**Havering**  
LONDON BOROUGH

**London Borough of Havering (20035775) – Response to the Secretary of State letter dated 28<sup>th</sup> November 2024.**

E. Work No. 9Z (Sheet 66) – Walking, Cycling, Horse Rider bridge over A127

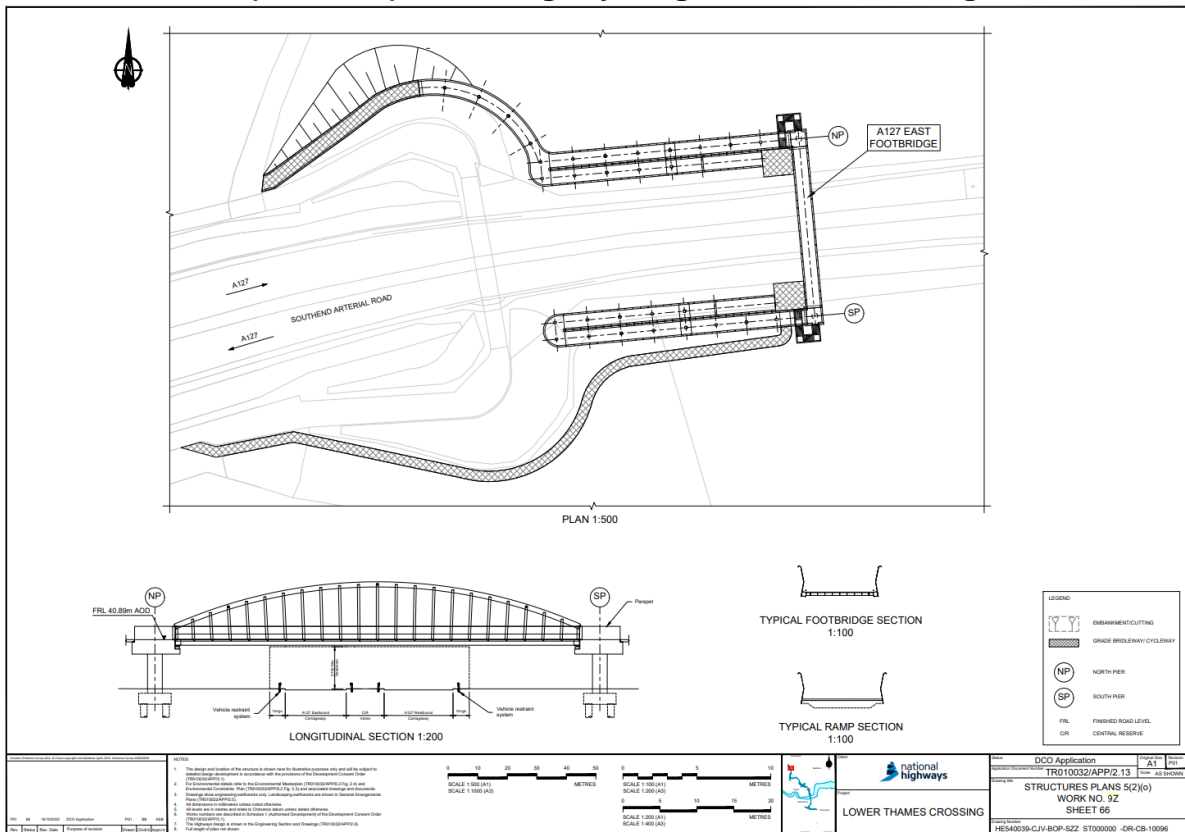
The Applicant has referred to the proposed footbridge that will be created over the A127 between Moor Lane and Folkes Lane to the west of Junction 29 of the M25. This new crossing has been strongly welcomed by the Council, however the clear expectation during the Examination was that this would be a walkers, cyclists, and horse riders (WCH) bridge rather than being limited to people on foot. In order to enhance active travel opportunities, it is considered essential that this structure is designed and built to enable it to be accessed by walkers, cyclists and horse riders and not simply limited to people on foot.

A matter that remained unresolved by the end of the Examination was connectivity to this structure, which was identified in Havering's final Principal Areas of Disagreement (PADS) document, and was categorised as a matter that was "*not agreed*" in the Statement of Common Ground between the Applicant and Havering.

Havering is of the view that a new dedicated Non-Motorised User (NMU) route should be created to provide a connection from the base of the proposed new A127 Footbridge, which would provide a safe connection up to Folkes Lane Woodland. The Council remains of the view that, given the new footbridge is being implemented to mitigate the impact of the LTC

project, a new NMU connection to Folkes Lane Woodland should be delivered as part of the project, and that this would enhance active travel opportunities.
